AB/36/21/A

11 High Street Arundel BN18 9AD

Installation of a free standing sign

Block Plan: 11 High Street, Arundel

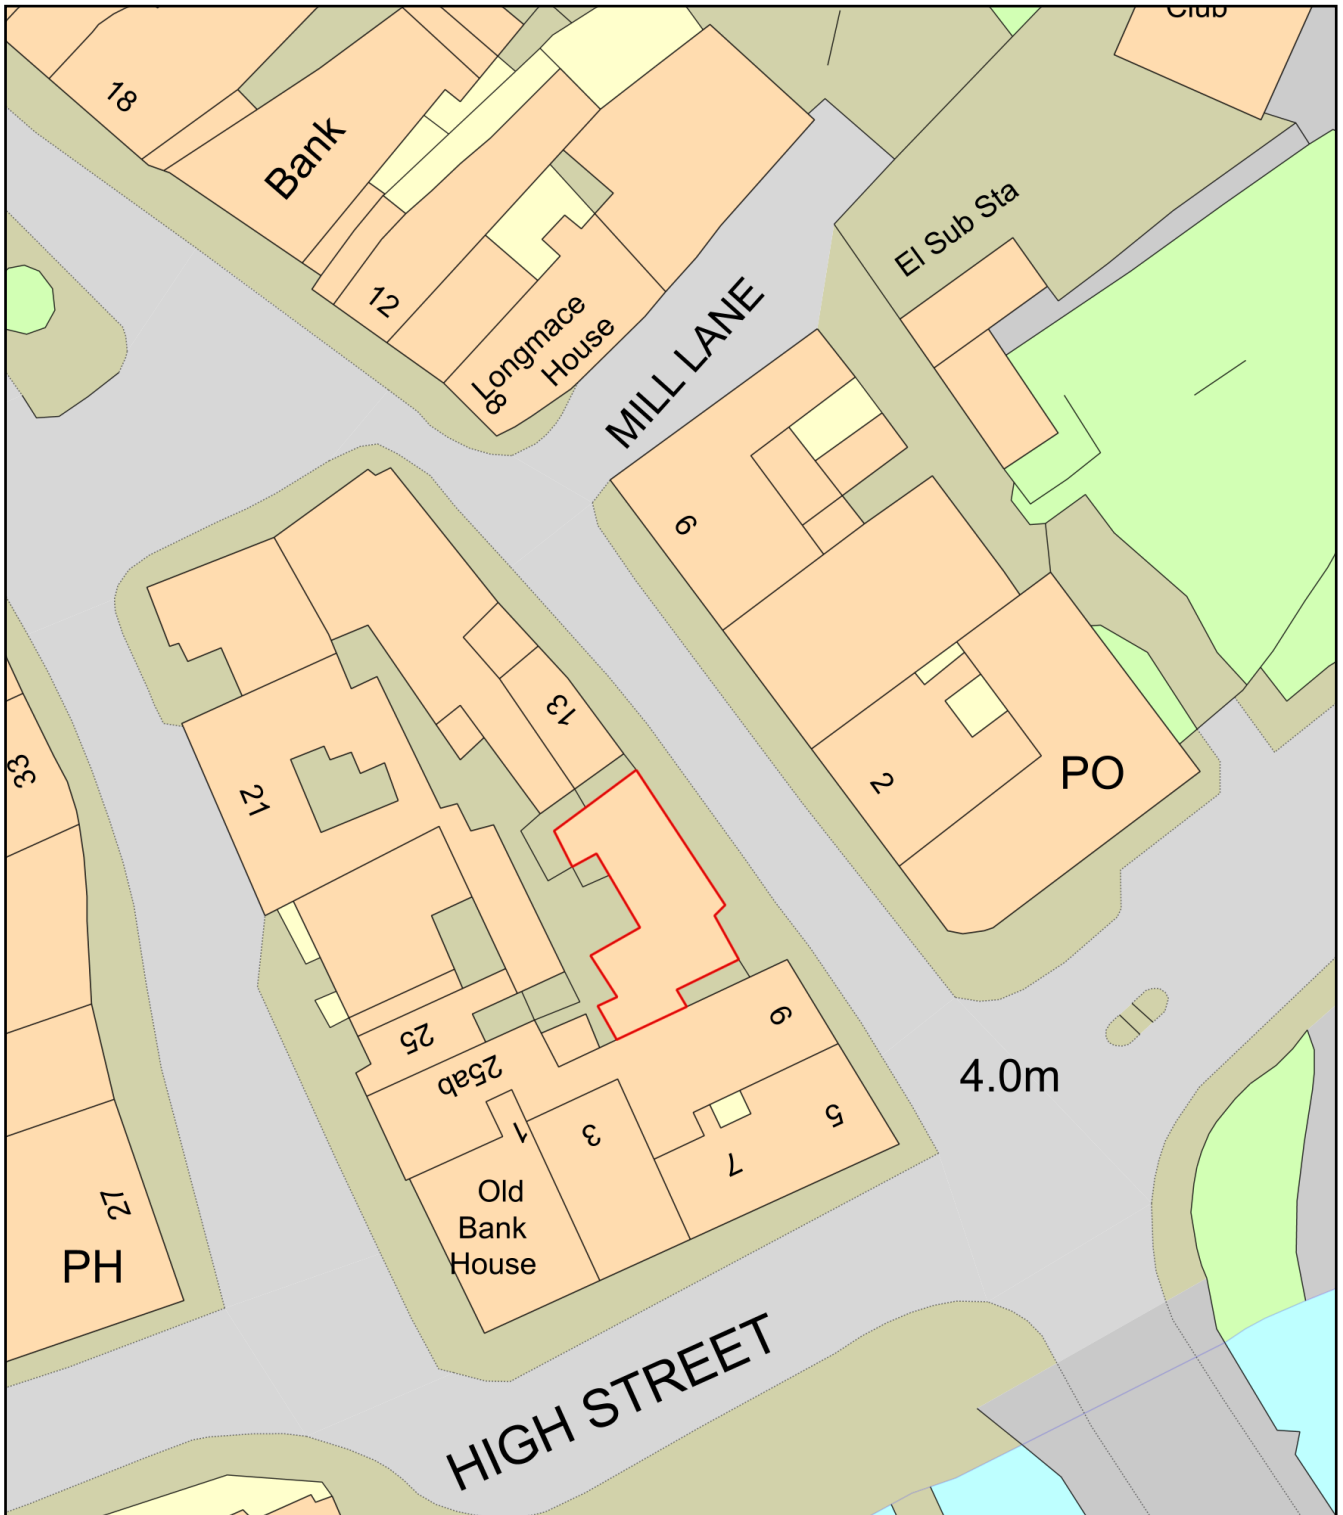
The proposal is for a free-standing sign. It appears that the sign is an 'a' frame advertisement, and it is assumed that it would be placed to the front of the listed building on the pedestrian pavement. It would help to understand where the applicants intend on placing the sign so that its impact can be fully understood. However, this information does not appear to have been supplied.
